Huntlee – Stage 1 MP10_0137 Modification 20 – Response to Submissions

Ethos Urban acts on behalf of Huntlee Pty Ltd regarding the section 4.55(2) Modification Application (MOD 20) to Project Approval MP10_0137, relating to the Huntlee New Town, Branxton. The purpose of this letter is to provide a Response to Submission (RTS) addressing the issues raised by the Department of Planning and Environment (DPE), other government agencies and public submissions received during the exhibition of the modification. The modification was publicly exhibited between 6 April 2022 and 19 April 2022. The submissions received are outlined below:

Figure 3 – Indicative layout for the roundabout controlled intersection of HEX link road and northern access road

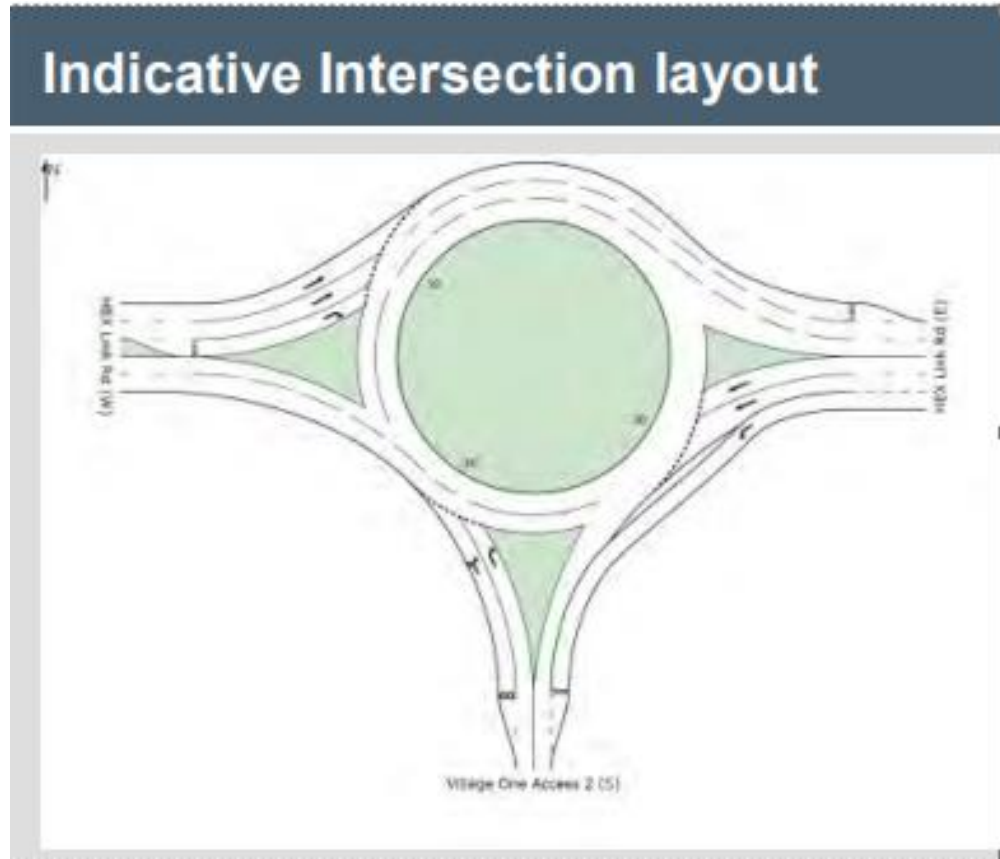
The Department notes that the existing condition E7(a)(ix) requires the delivery of Hex Link Road / Village 1 North access (A-6) intersection and link road prior to the registration of 1500 Lots within Village 1. This modification seeks to delay this infrastructure until the registration of 1950 lots within Village 1.

The Department questions the delay of this infrastructure beyond the number of lots currently approved (and sought) within the Village 1 area (1457 lots, being substages 2-15) with no apparent additional land available for future subdivision within this area. The Department does not support the delaying of this infrastructure beyond the number of lots achievable within the Village 1 area. Further information to justify this aspect of the proposal is required.

The lot count plan submitted with Mod 20 identifies a total number of lots intended to be created as 1,989, in excess of the proposed 1,950 lot trigger for the upgrade of the left-in/left-out to a roundabout. As such the request is not to delay infrastructure beyond the scope of the Stage 1 DA as amended by Mod 20 if the traffic report and TfNSW concur to the new trigger for the roundabout construction. Furthermore, the Traffic Modelling Report for the Stage 1 Approval provides that the intersection is required for the full development – which is based on a residential yield of 7,500 dwellings. Stage 1 was modelled for traffic purposes on a yield of 2,345 dwellings (being 2,045 residential dwellings on residential land, and 300 dwellings within the Town Centre).

Access to Village 1 under the Stage 1 road upgrades from the Traffic Modelling Report does not indicate that intersection A-6 is required – only A-1, A-2, A-3 and A-5 (and A-9, near the large lots) are identified as proposed access points. It is intended that A-6 will be constructed as a left-in/left-out interim arrangement prior to June 2023, and then upgraded to a roundabout or traffic signals, during Stage 1, prior to 1,950 allotments. The additional 450 lots on top of the 1,500 per the current condition wording has been assessed by SECA Solution based on 2020 traffic data collected, prior to the provision of the roundabout intersection upgrade at A-6.

Figure 5 Substage 13 as proposed to be modified

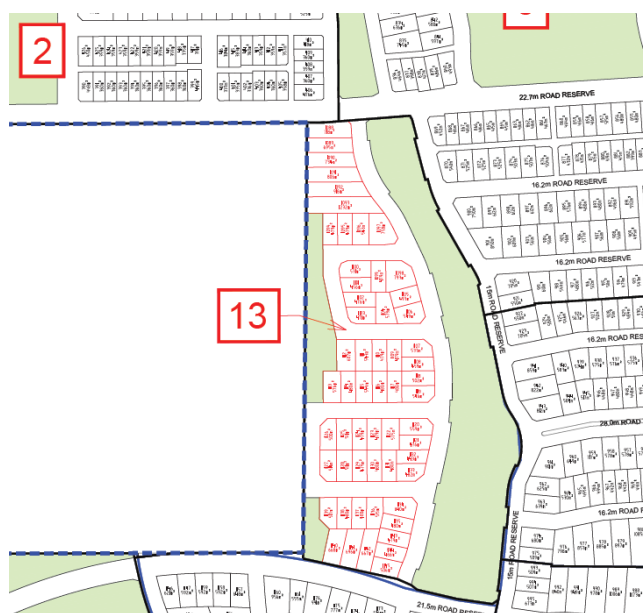
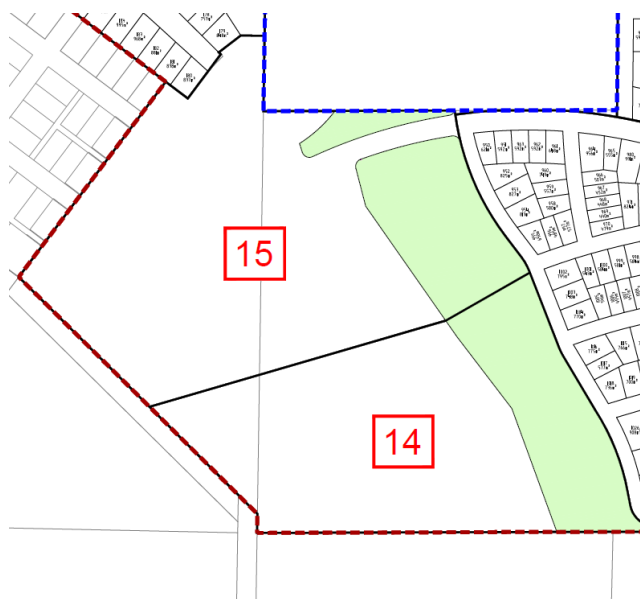
The modified layout of Substage 13 seeks to remove opportunities for future road connections to Lot 34 DP 755211, and introduce small areas of open space. The Department questions the usability of these areas of open space being narrow in width and recommends that the modified layout of Substage 13 be reconsidered. In addition, the Department recommends you seek Bushfire Protection advice from an accredited Bush Fire Consultant for Substage

13 to allow for a cohesive subdivision pattern to be established across the subject site and Lot 34 DP 755211 and remove the need for the additional open space which Cessnock Council are not supportive of maintaining.

The adjustment of the road and allotment layout in substage 13 remains consistent with the original intent of the Stage 1 Approval, as it still provides for residential development with public roads and access to open space. Road connectivity is still achievable to Lot 34 from the Huntlee development.

The development of sub-stage 13 as currently approved does not address stormwater quality and quantity prior to entering Lot 34. Given there is currently no DA in process over lot 34, no development of sub-stage 13 can currently occur without the new proposed stormwater management measures as documented in this modification, therefore preventing the development of approximately 58 residential lots.

LONGITUDINAL SECTION ALONG MC17
HORIZONTAL SCALE 1:500@A1
VERTICAL SCALE 1:100@A1

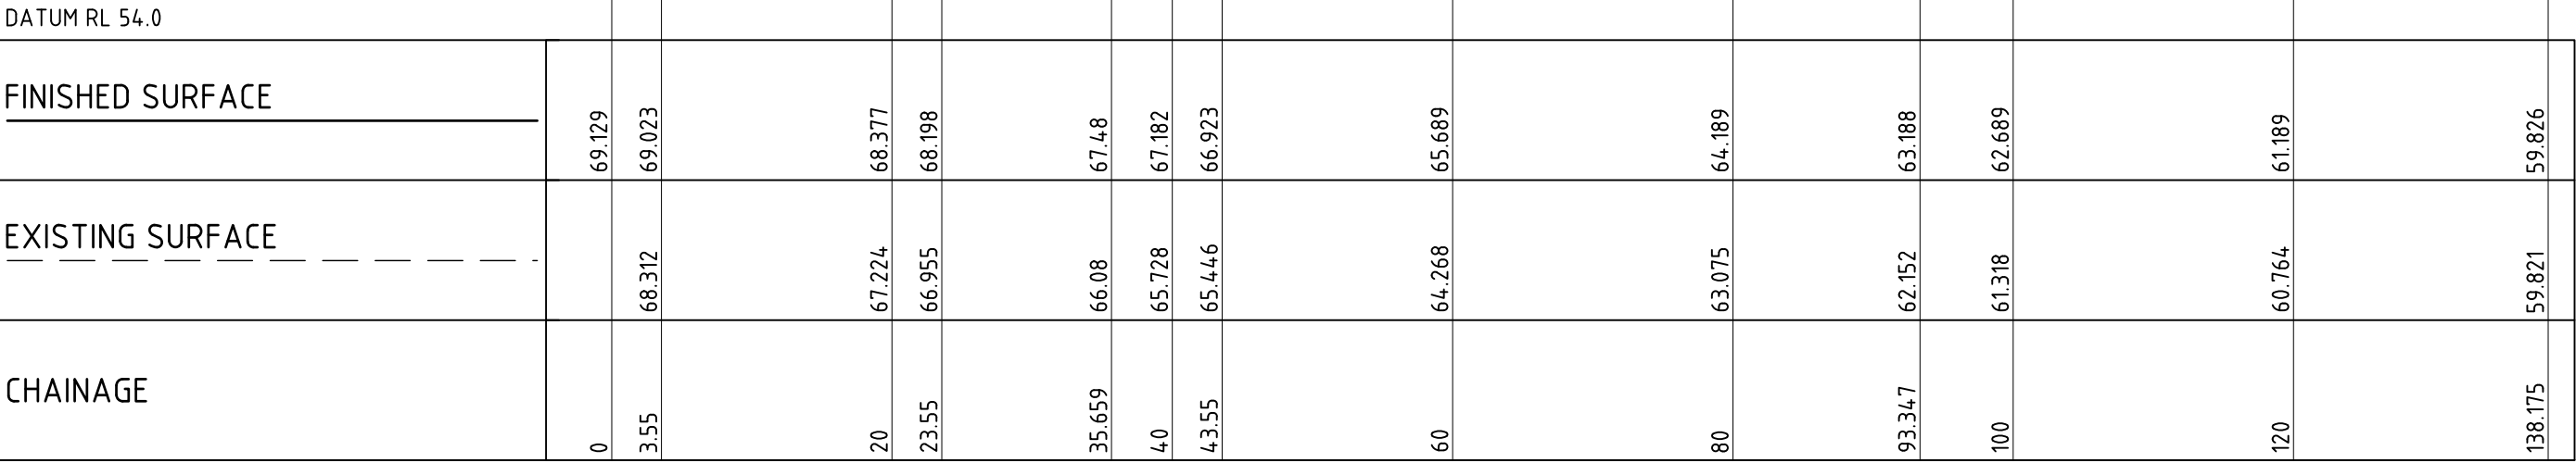
The application as submitted has not included the civil documentation for the proposed modification and the associated infrastructure that is required. The Department requires that concept civil documentation for all infrastructure associated with this modification be provided, including contours and any cut / fill required.

Civil Plans have been prepared that identify the current indicative levels of cut and fill required. It is noted, however, that Conditions C11 and C12 provide for detailed engineering plans to be submitted to and approved by the Certifying Authority, prior to the release of the relevant construction certificate:
